PDW/20023

08 June 2021

Approval of details reserved by condition imposed under ref P/140/16/OUT relating to Condition No 6 - design code masterplan Location: Land South Of Summer Lane & West Of Pagham Road Pagham -- LA Ref P/83/21/DOC.

Development Framework Plan by Davies' Landscape Architects submitted in support of P/140/16/OUT

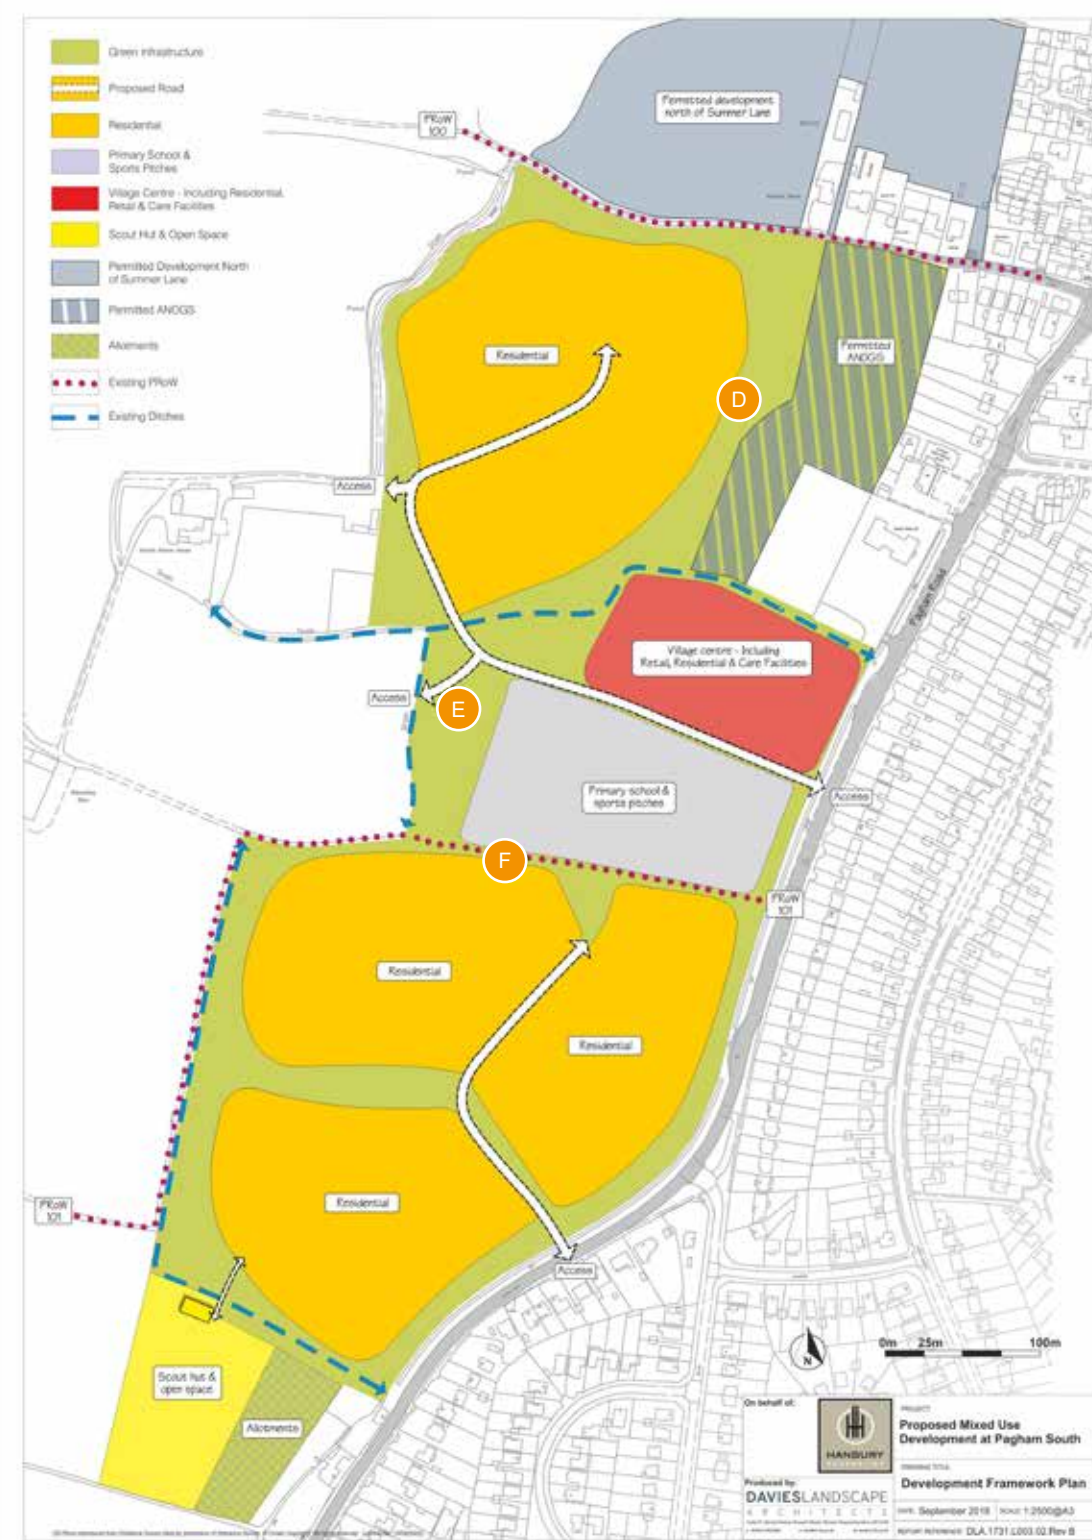
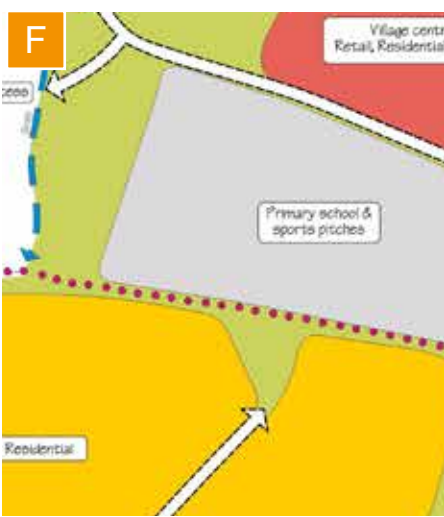
The Design Code masterplan does not reflect the objectives of the Illustrative Master Plan, the Density Plan, the Development Framework Plan or the Internal Movement Strategy Plan all referred to in the condition. They all show two road and footpath connections into Church Barton Farm but these are all absent from the Design Code. The Wider Development Framework Plan 1731.L003.15 actually shows the consented Church Barton Farm application land with road connections into 3 proposed residential blocks. All the Design Code is intended to do is provide further details on matters such as character areas, street hierarchy building typologies, key buildings, the approach to car parking, structural planting, street furniture, lighting and treatment of the public realm. Instead by deleting the intended vehicular and pedestrian connectivity shown at outline stage it is now in conflict with Local Plan policy H SP2 because it is no longer able to deliver the comprehensive master planning requirements of the policy.

The only application plan for P/140/16/OUT that could possibly fall within this definition would be the Illustrative Master Plan. However, the other Plans listed in Condition 6 comprising the Density Plan, the Development Framework Plan and the Internal Movement Strategy Plan also show connections to Church Barton Farm and are not annotated as illustrative. Therefore, even if the applicant wanted to make a case that the masterplan should not be relied on, the other plans forming part of the development for which the application was made show the connections to Church Barton Farm, and to use the Design Code to circumvent this and deny prospects for a comprehensive development would be in conflict with Local Plan policy H SP2 anyway.

For all these reasons the application to discharge condition 6 of application P/140/16/OUT with the submitted Design code **should be refused permission** and the applicant requested to submit a fresh Design Code that reflects the plans agreed at outline stage to allow the delivery of a comprehensive development all in accordance with policy.
